RE: 6/2018/2241/FULL - Ocado Ltd, Gypsy Moth Avenue, Hatfield, AL10 9BD

Thank you for consulting us on the above full planning application for the erection of an ancillary Vehicle Maintenance Unit (VMU) to serve the existing distribution unit (6/2018/2241/FULL).

Title
As Built Drainage layout

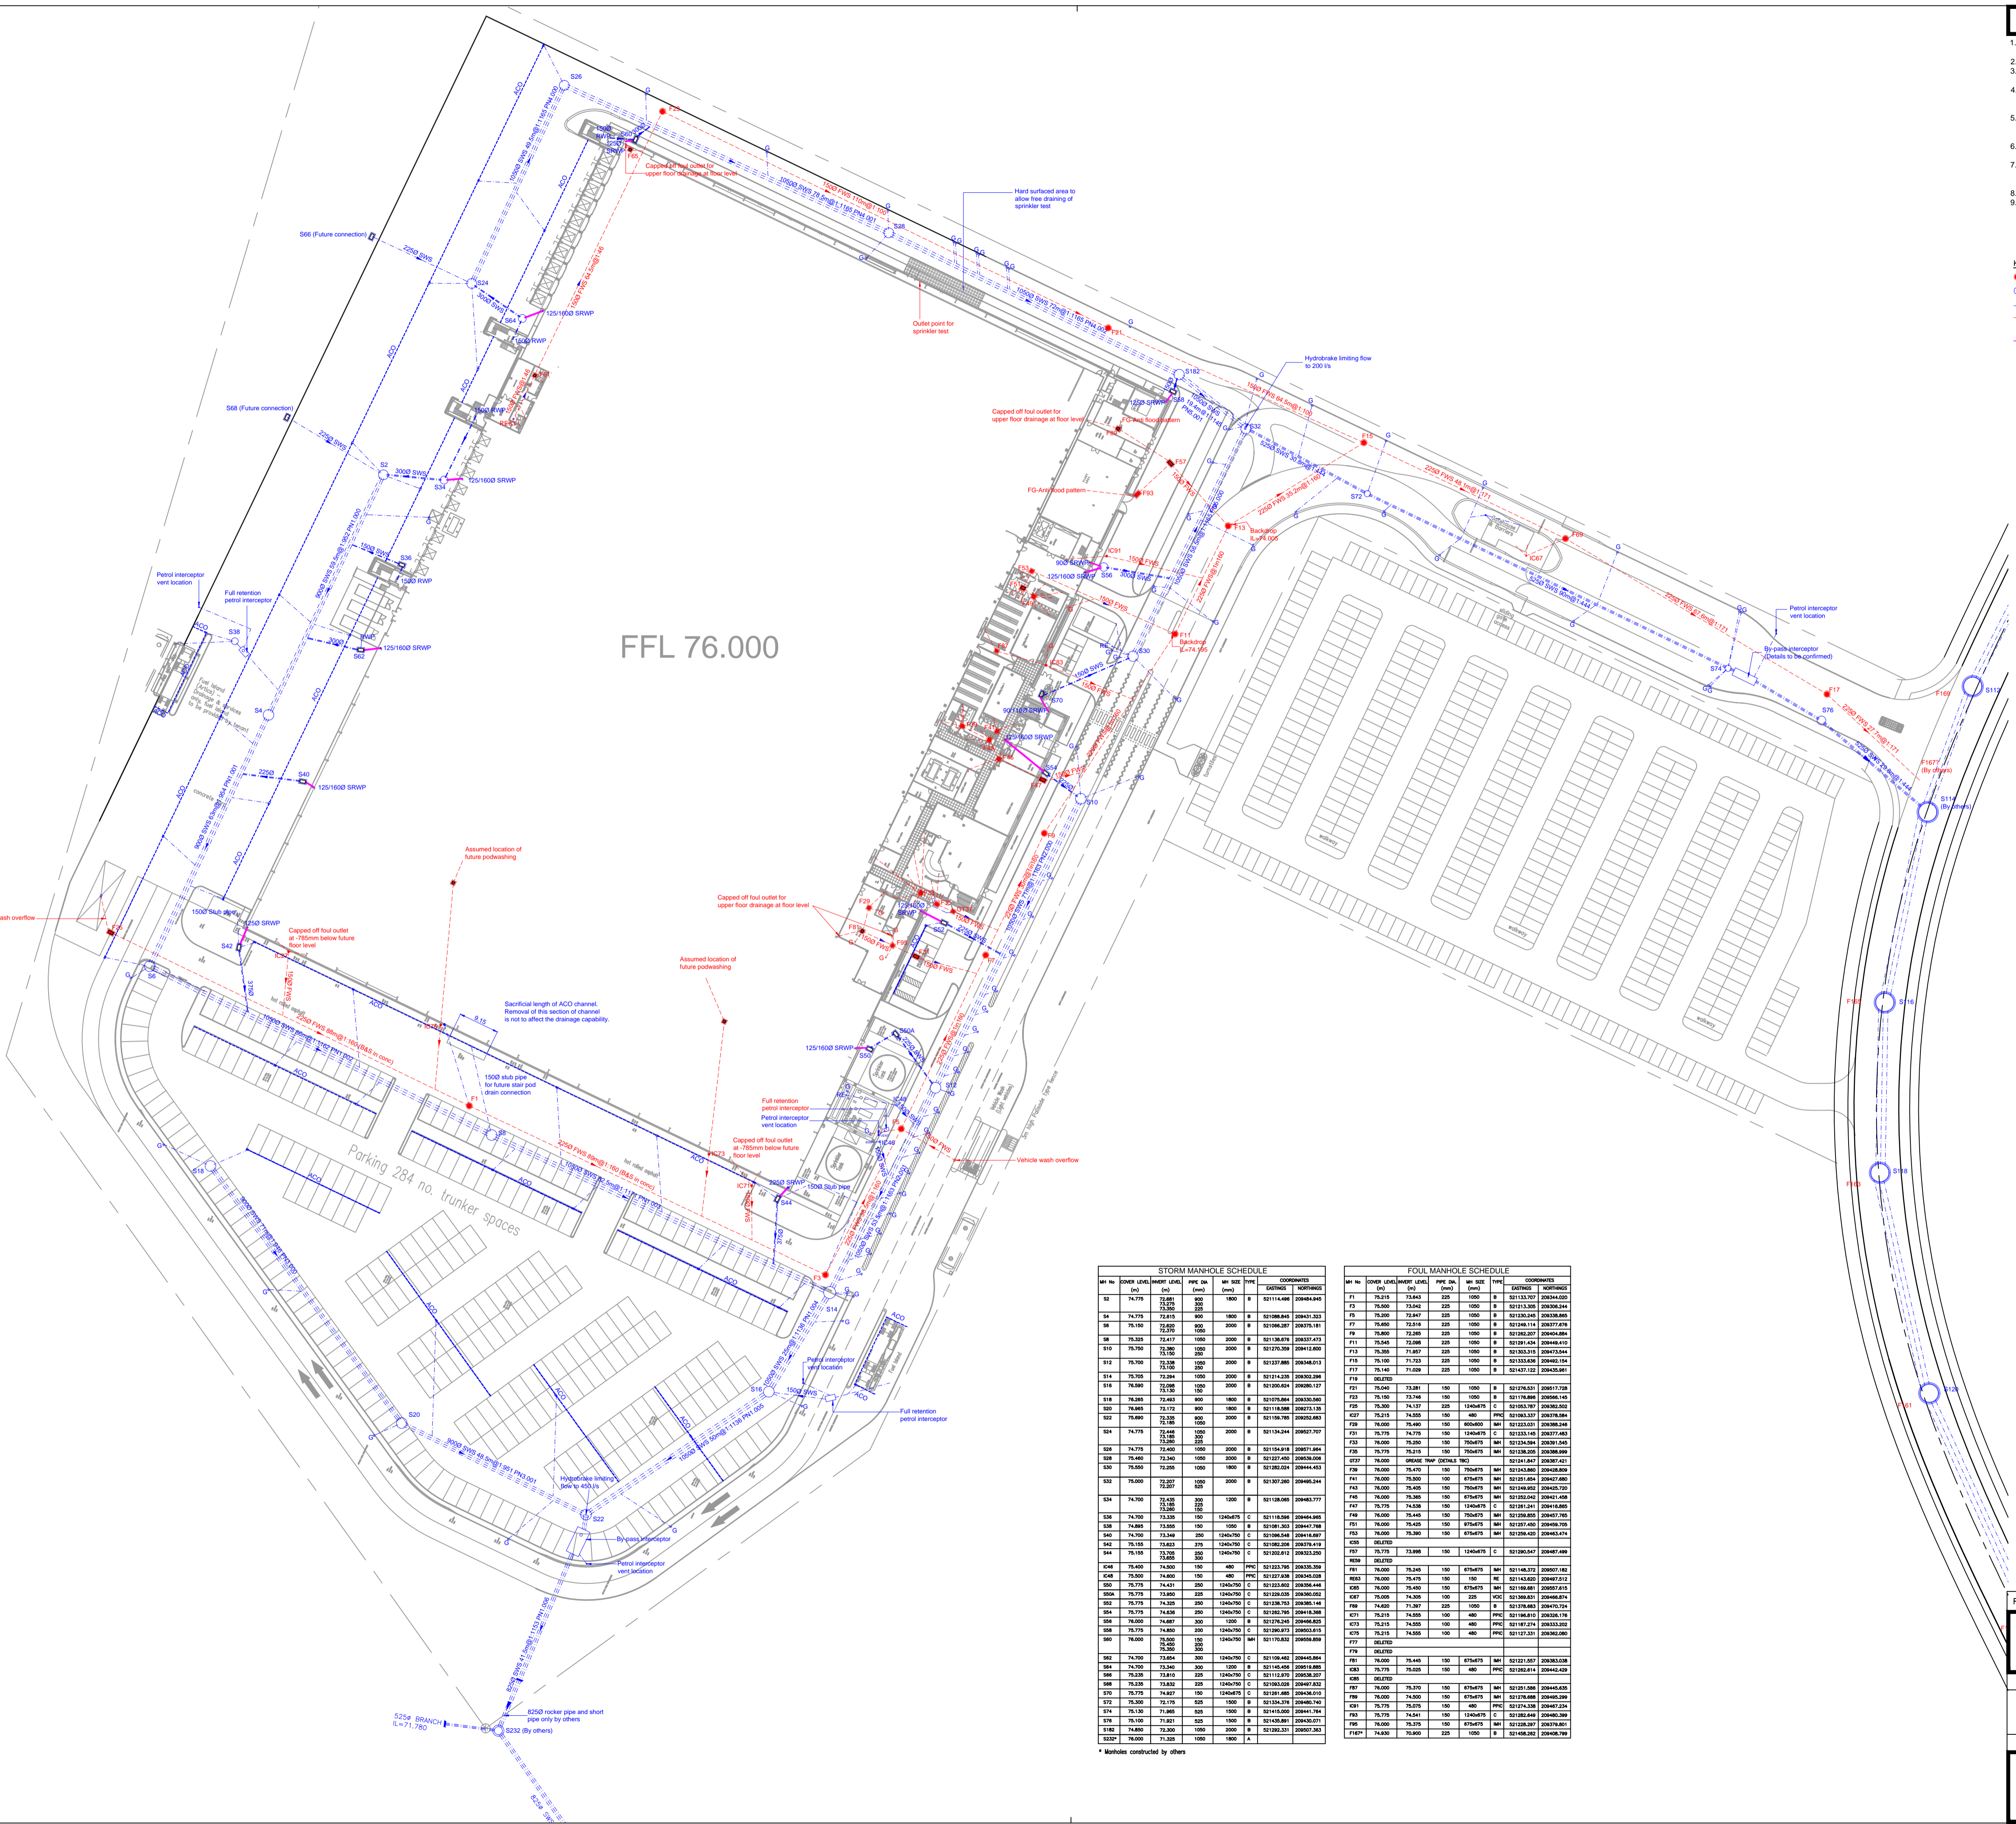
Any hardstanding used for vehicle washing should go to the foul sewer network. The “As Built Drainage Layout” dated 27/11/00 in Appendix A shows the location of a “Vehicle wash overflow” and “Assumed location of future podwashing”. The Drainage Statement states that there is no foul drainage proposed as part of the VMU works. From the information shown in Appendix A it appears that the foul drainage is in place for these works, however the Drainage Statement states how no foul drainage works are proposed. The LPA should confirm that any wastewater from the VMU drains to the foul sewer network.
